Minutes for November 21, 2016

Early Assistance Meeting – EA-16-116 – Vollbracht Minor Subdivision

The application request is to subdivide 37 acres into 4 lots.

Concept Plan

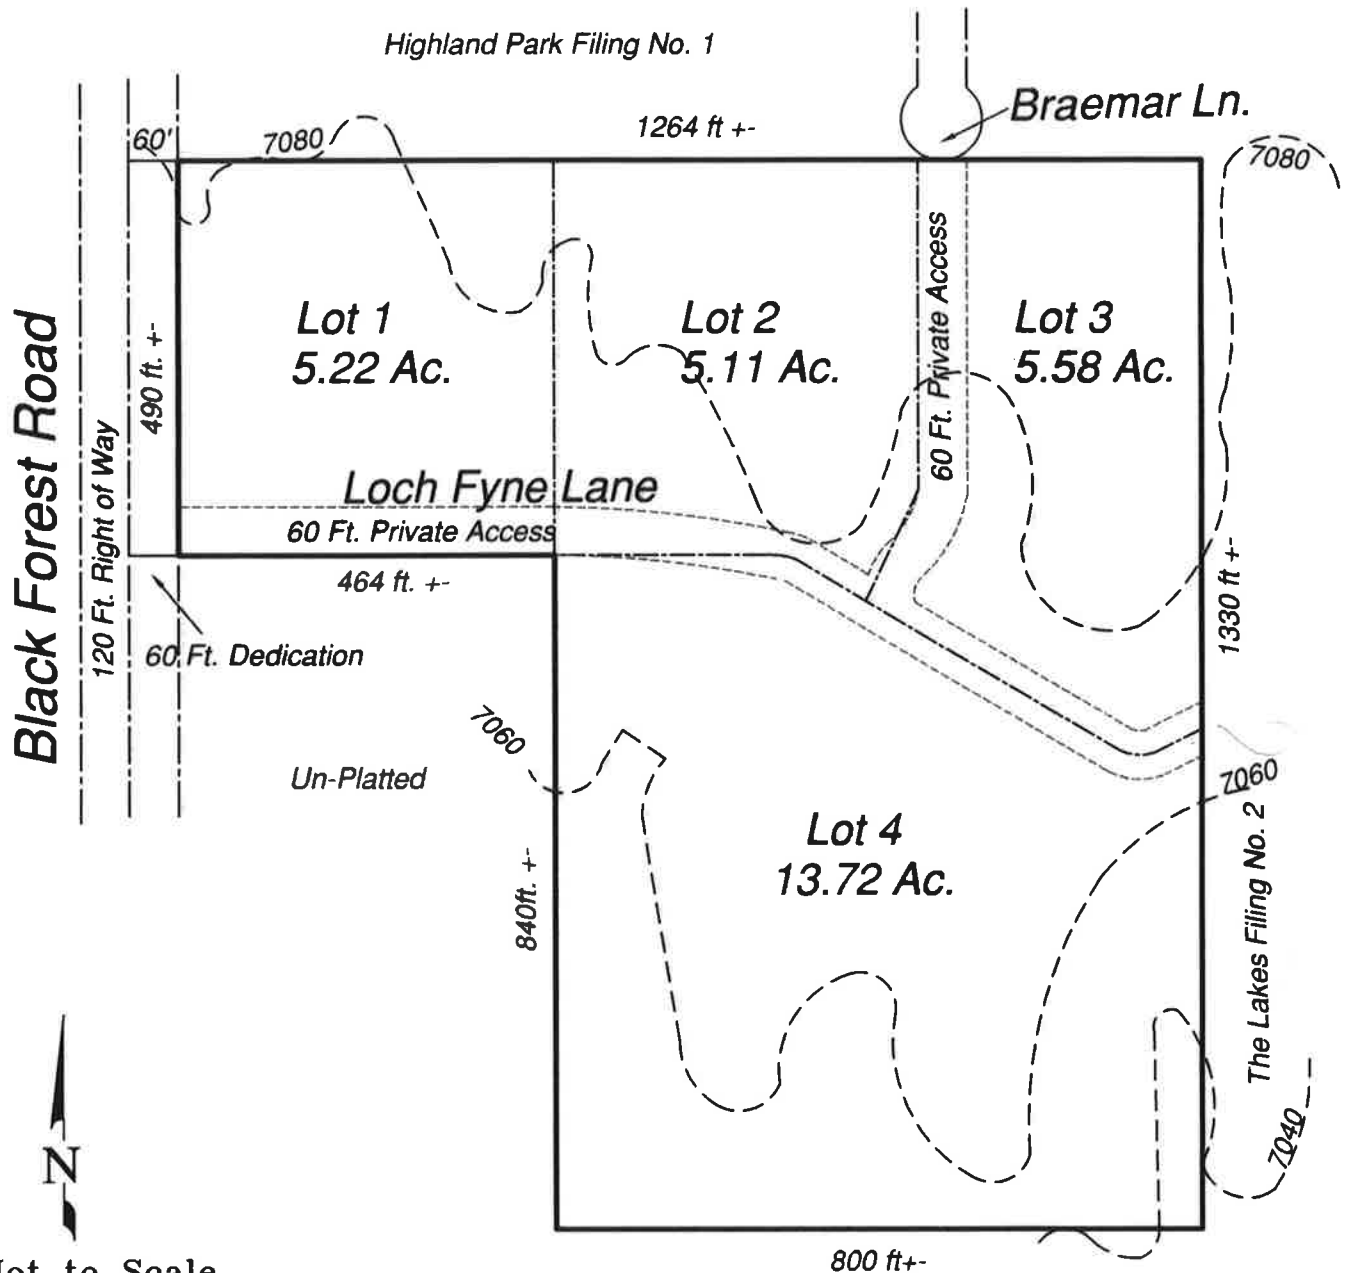
- Based on information provided, a Transportation Impact Study (TIS) is not required.
- County Road Impact Fee is required for each additional lot created which may be paid at the time of plat recordation or at building permit issuance.
- Black Forest road is classified as a Minor Arterial road (100' Right-of-Way). Right of way dedication may be required if the existing ROW line is less than 50 ft. from the road centerline.
- The existing access from Black Forest Road is not approved and will need to be abandoned. Access will be taken from the proposed Braemar Ln. extension.
